**Our Case Number:** ABP-319397-24

**Re:** Substitute consent for quarry and ancillary precast concrete manufacturing yard.  
Tromman Quarry, Tromman, Rathmolyon, Co. Meath.

Extracted from  
Map Series | Map Sheets  
1:2,500 | 2915-B  
1:5,000 | 2915  
1:5,000 | 2847

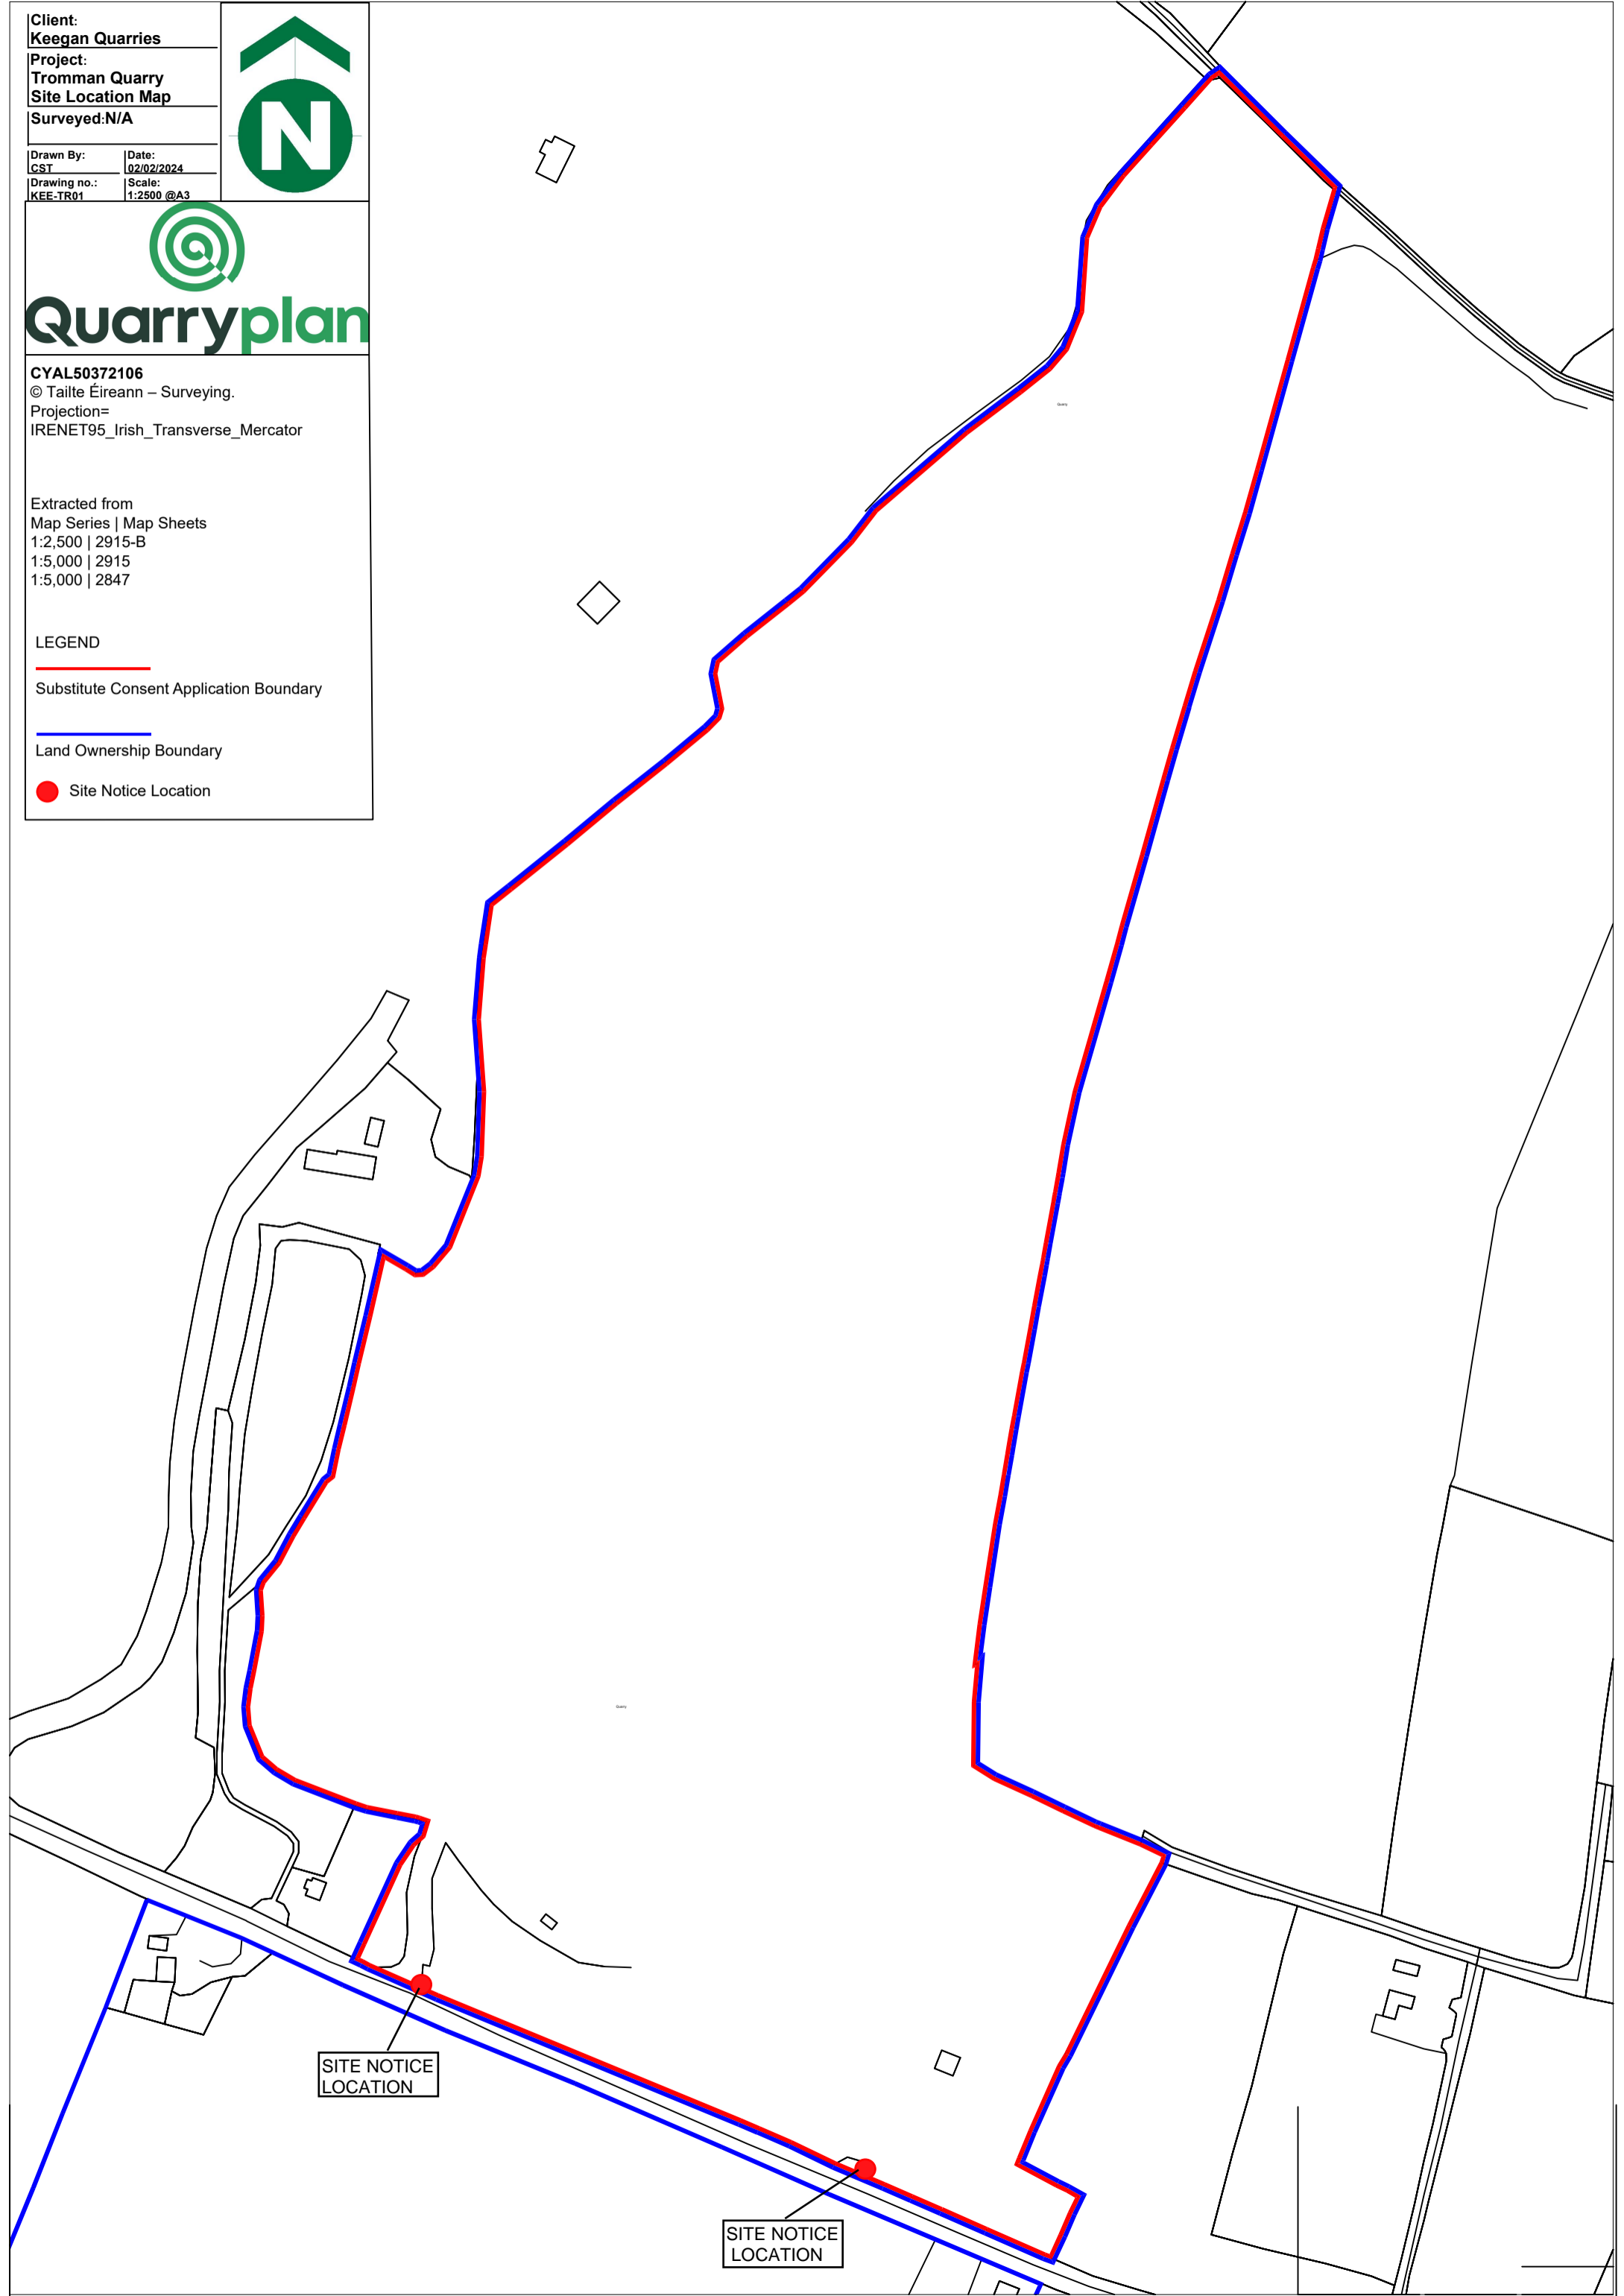
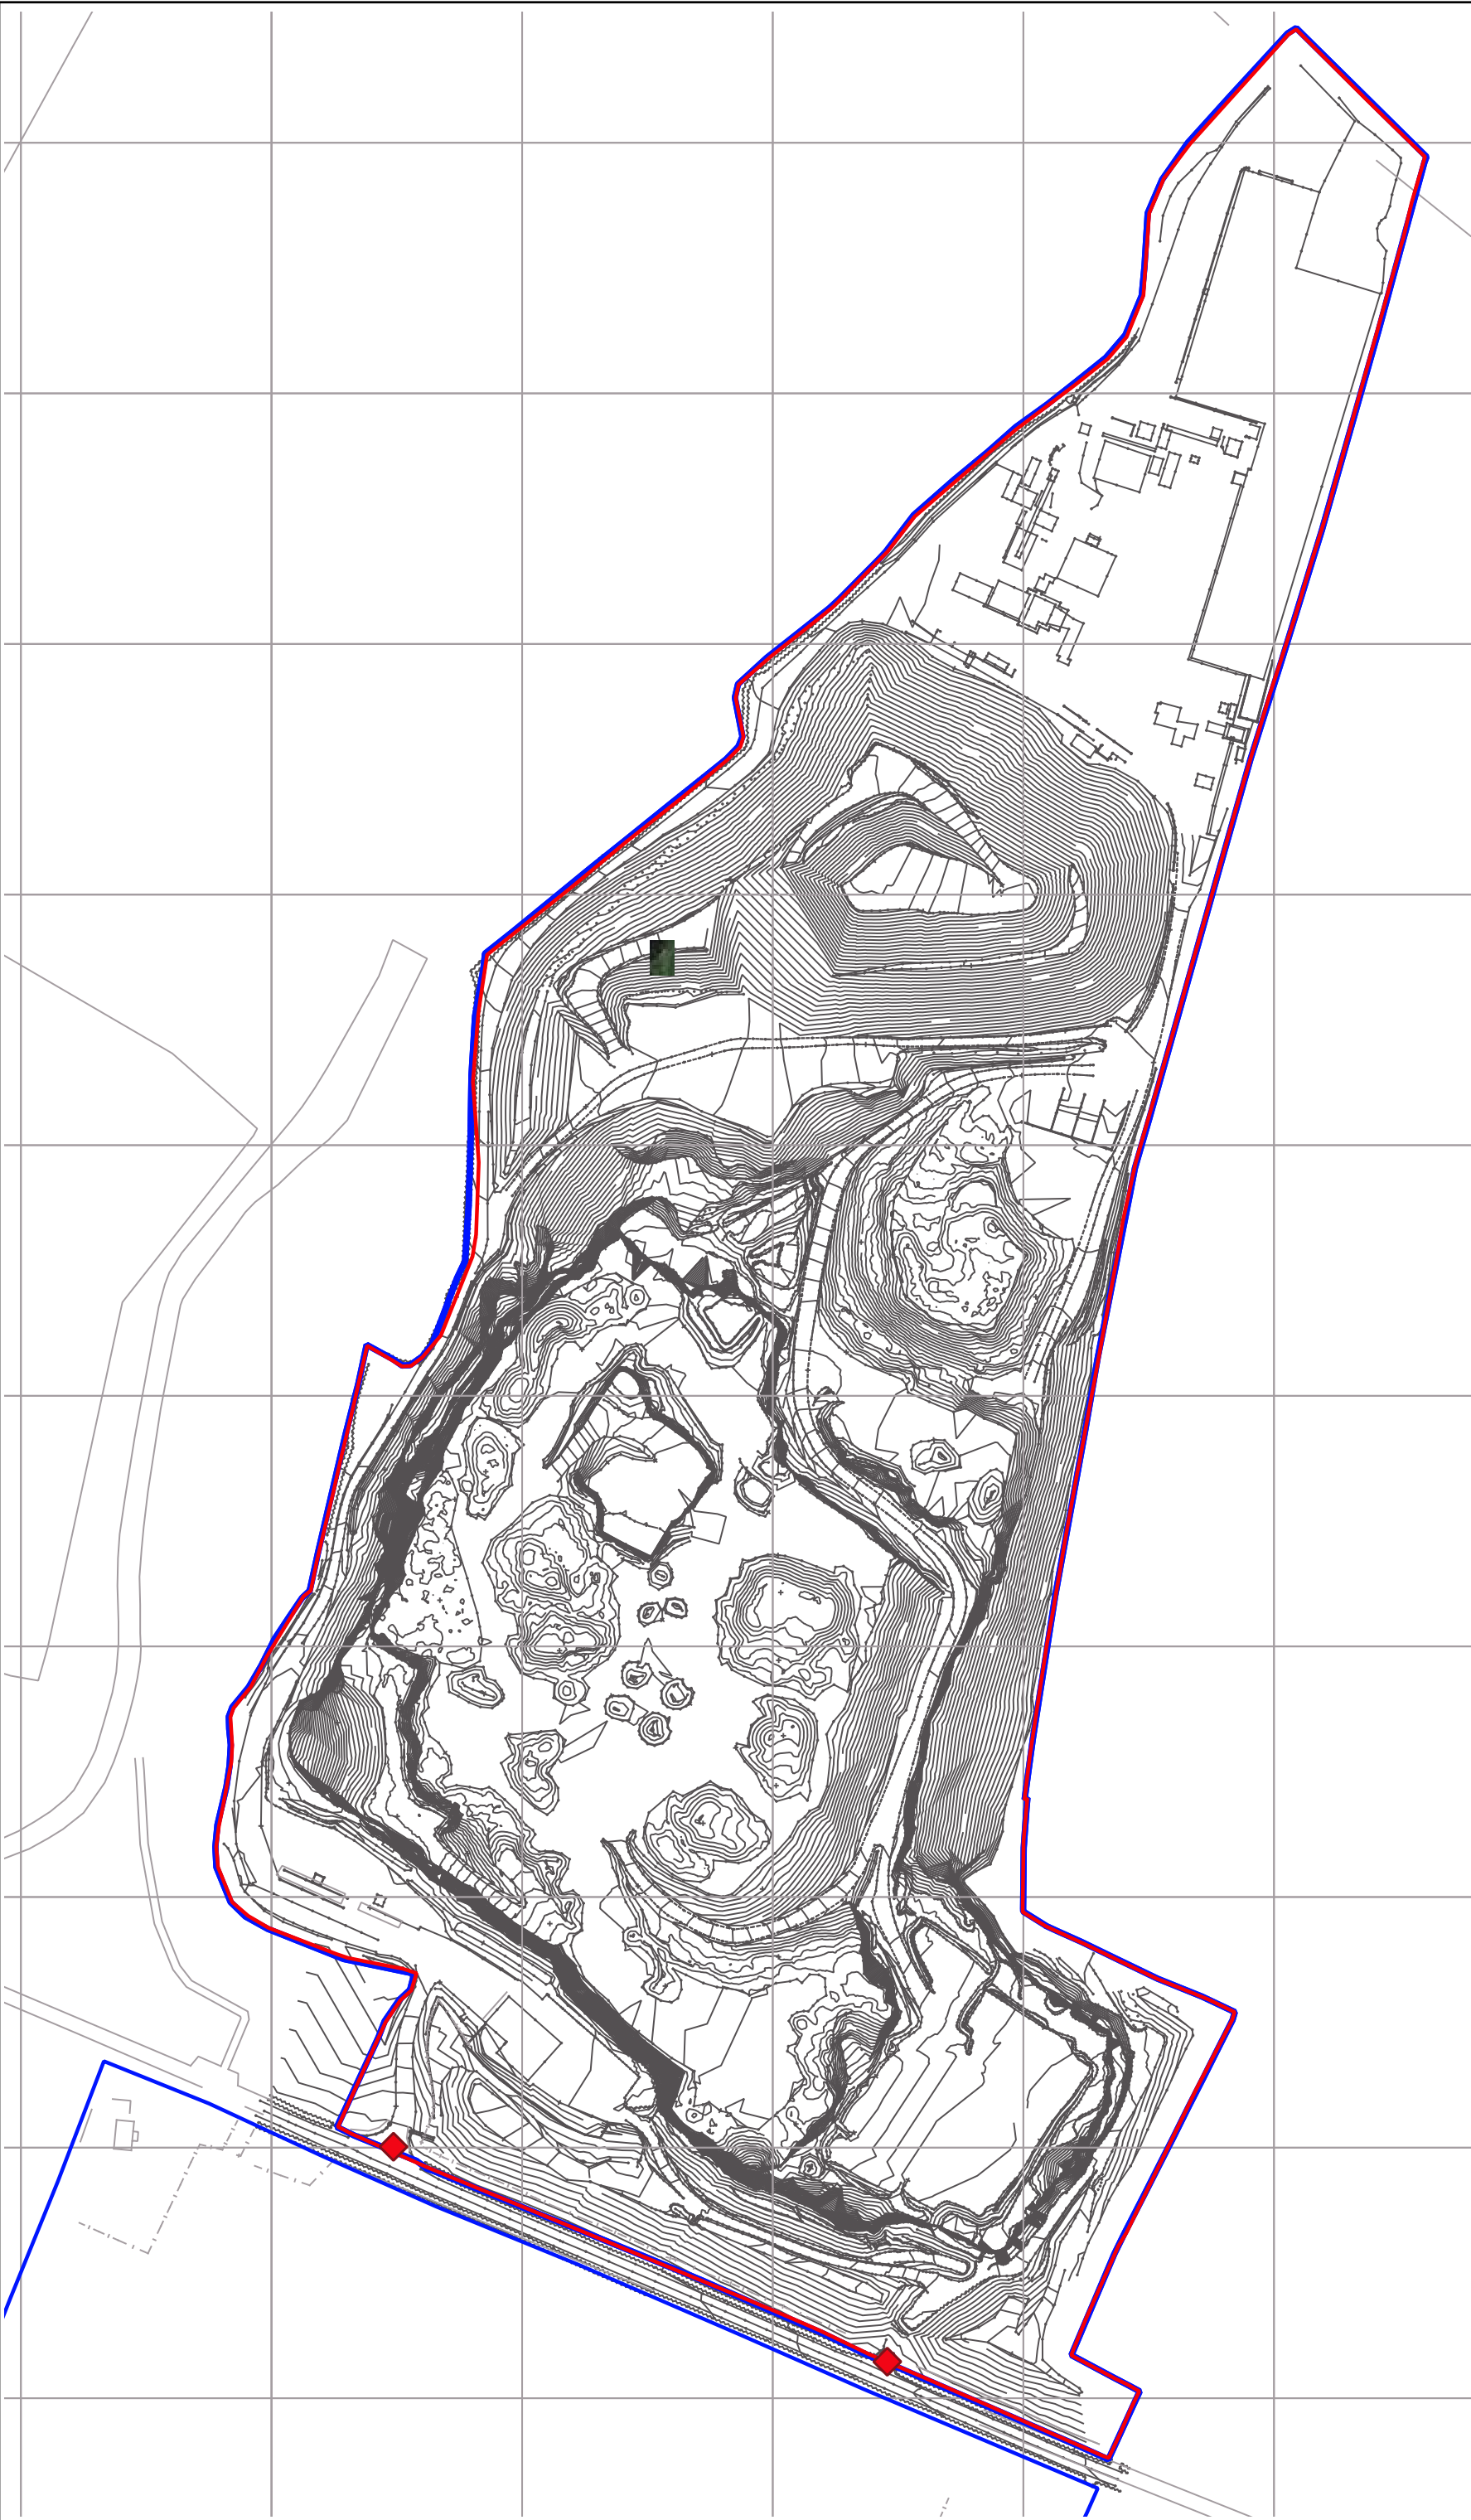
- (1) A new Site Location map to be of sufficient size and containing details of features in the vicinity such as to permit the identification of the site to which the application relates in accordance with Article 227(2)(b) of the Planning and Development, Regulations 2001, as amended.**
